**Re: Status of Improvement Permit Application #06-5-16265 – Lot 8  
The Highlands at Sherwood Forest**

On September 26, 2006, an Environmental Health Specialist from the Harnett County Health Department attempted to evaluate your property for the purpose of issuing an Improvement Permit. This individual was unable to evaluate your property for one or more of the following reasons.

Revision
SITE PLAN APPROVAL w/ Garage
DISTRICT REBAR USE TUMBLE

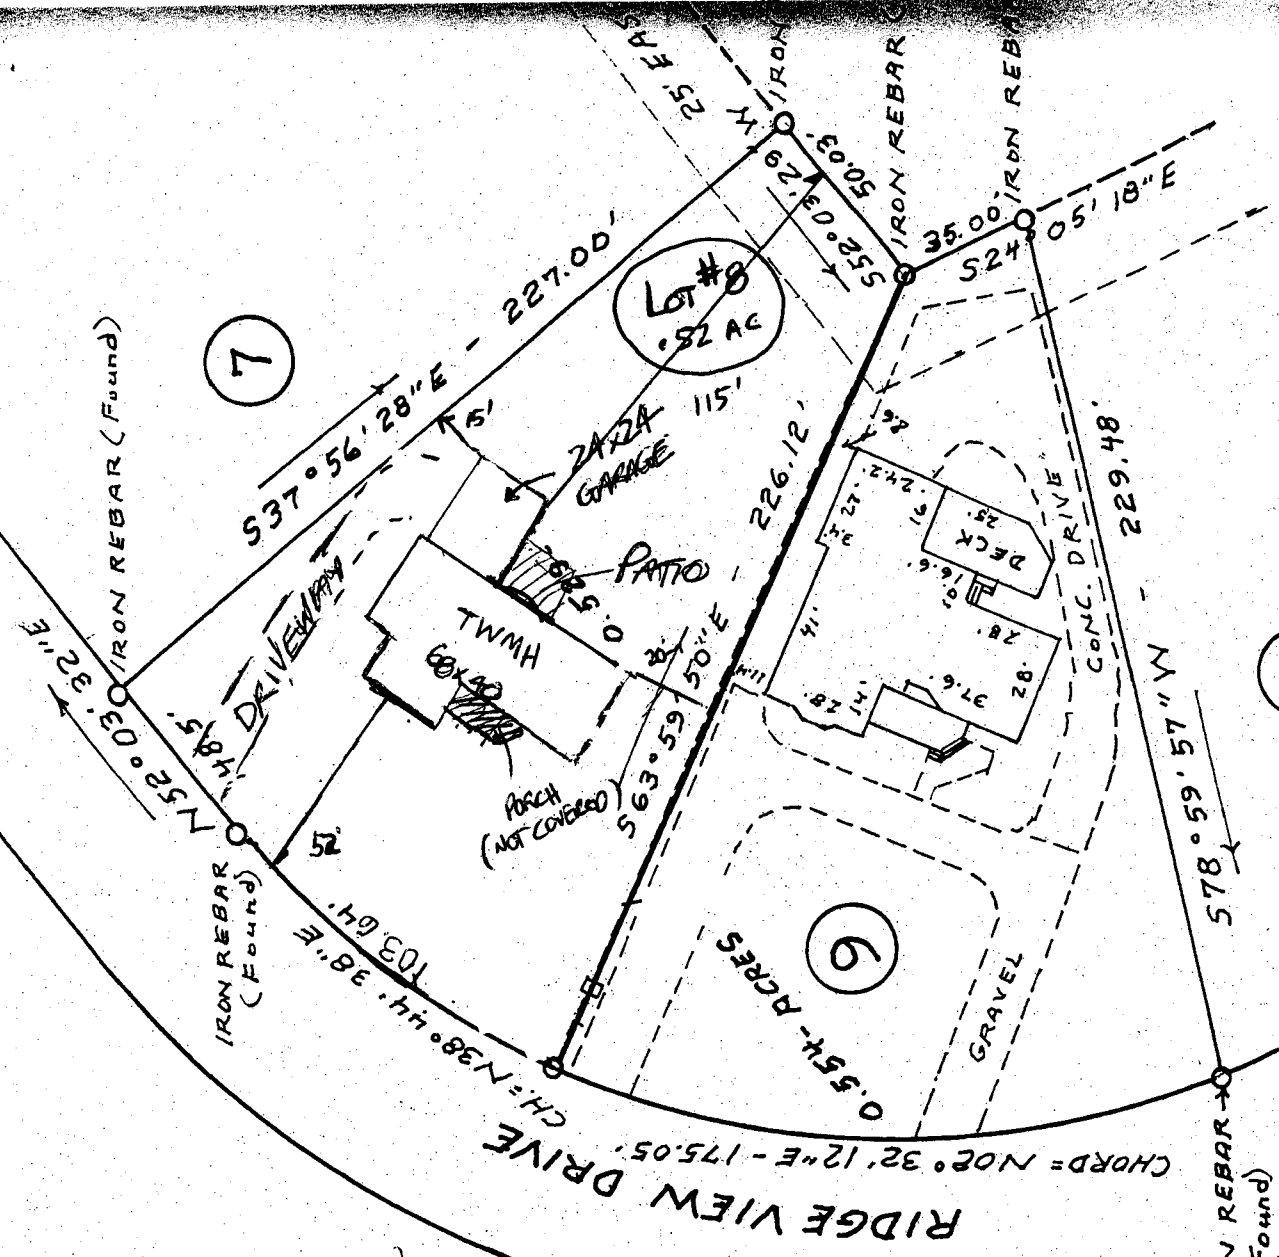
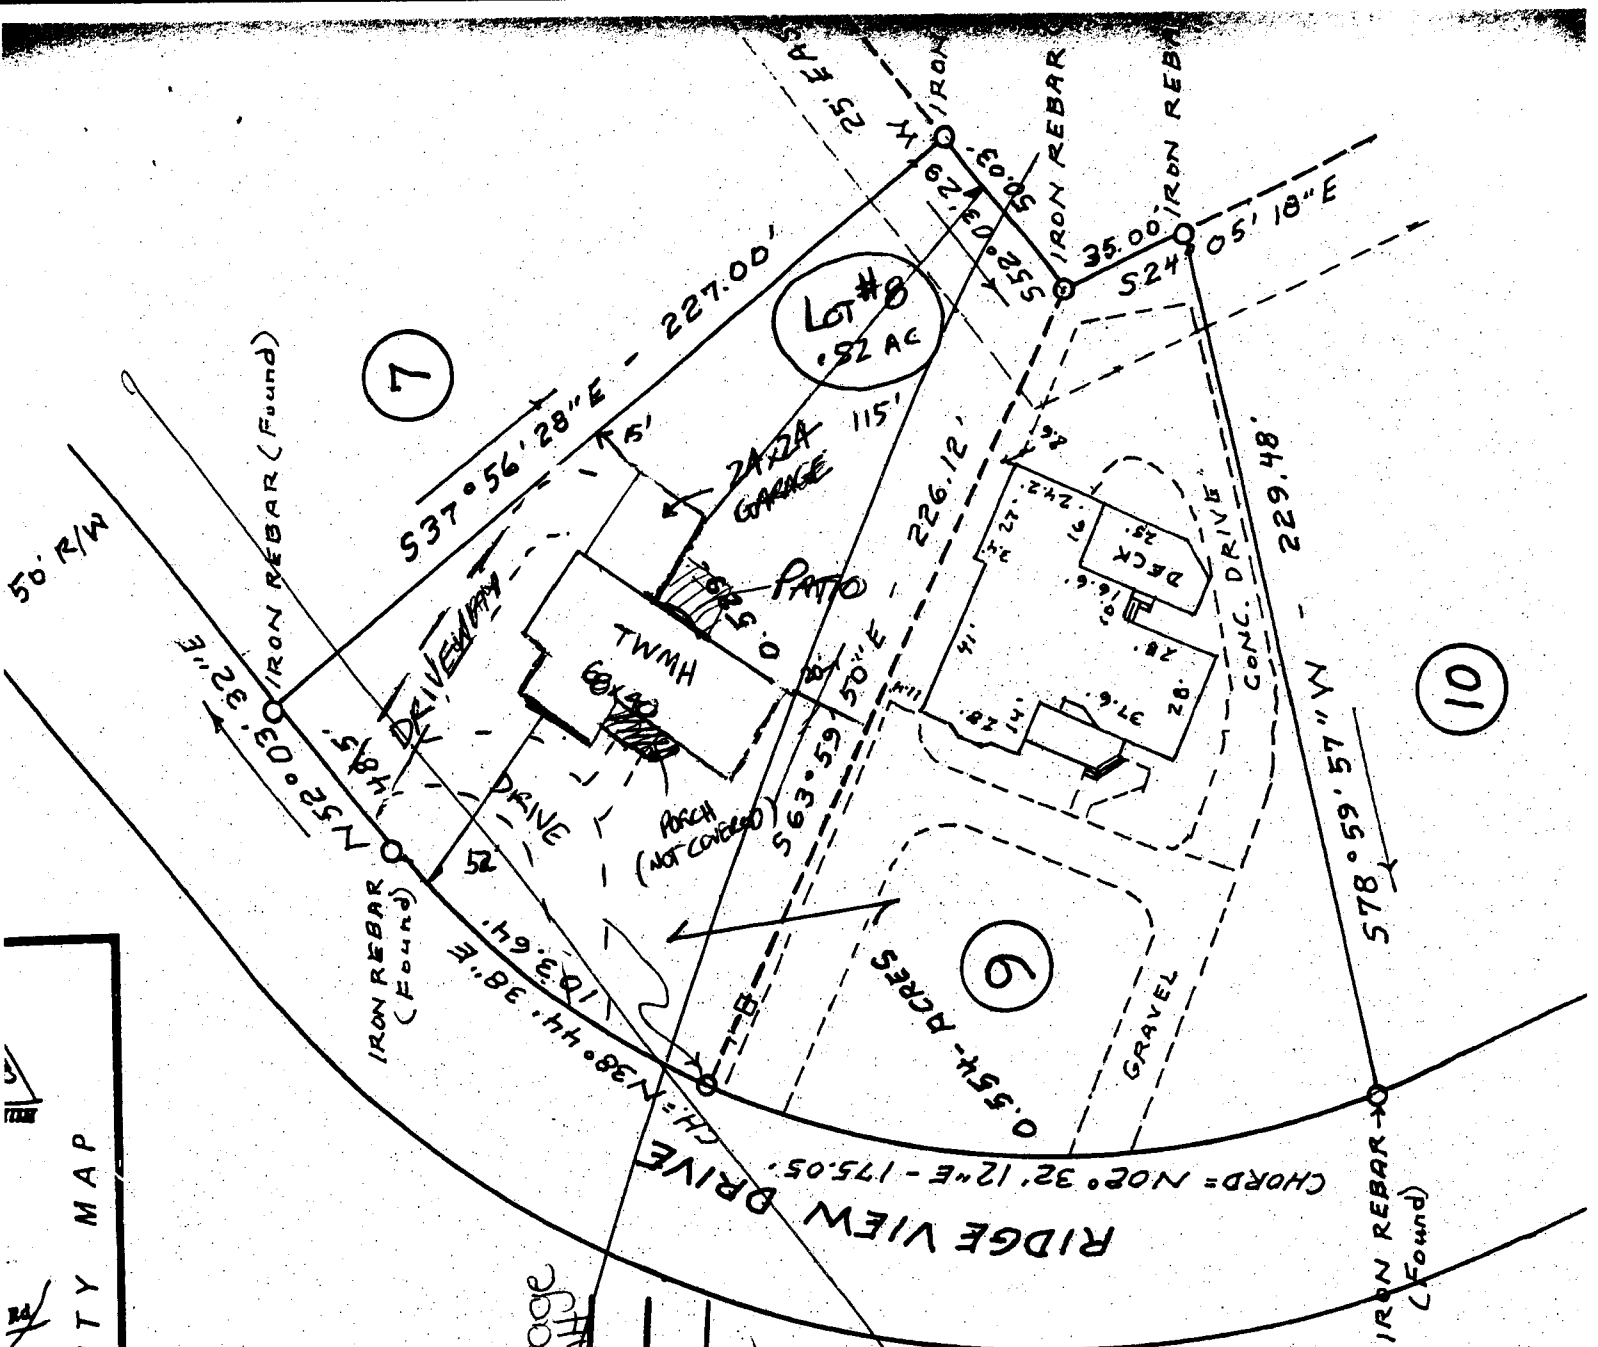
- 1. Property lines/corners not marked or labeled
- 2. House corners not marked or labeled
- 3. Directions not clear to property
- 4. Property needs brush or vegetation removed
- 5. Backhoe pits required
- 6. Other – **Map/plot plan submitted by you shows lot 8 and 9 combined. But information you've given, is for lot 8 as a stand alone lot. Please submit correct plot plan to Central Permitting as a revision and reconfirm.**
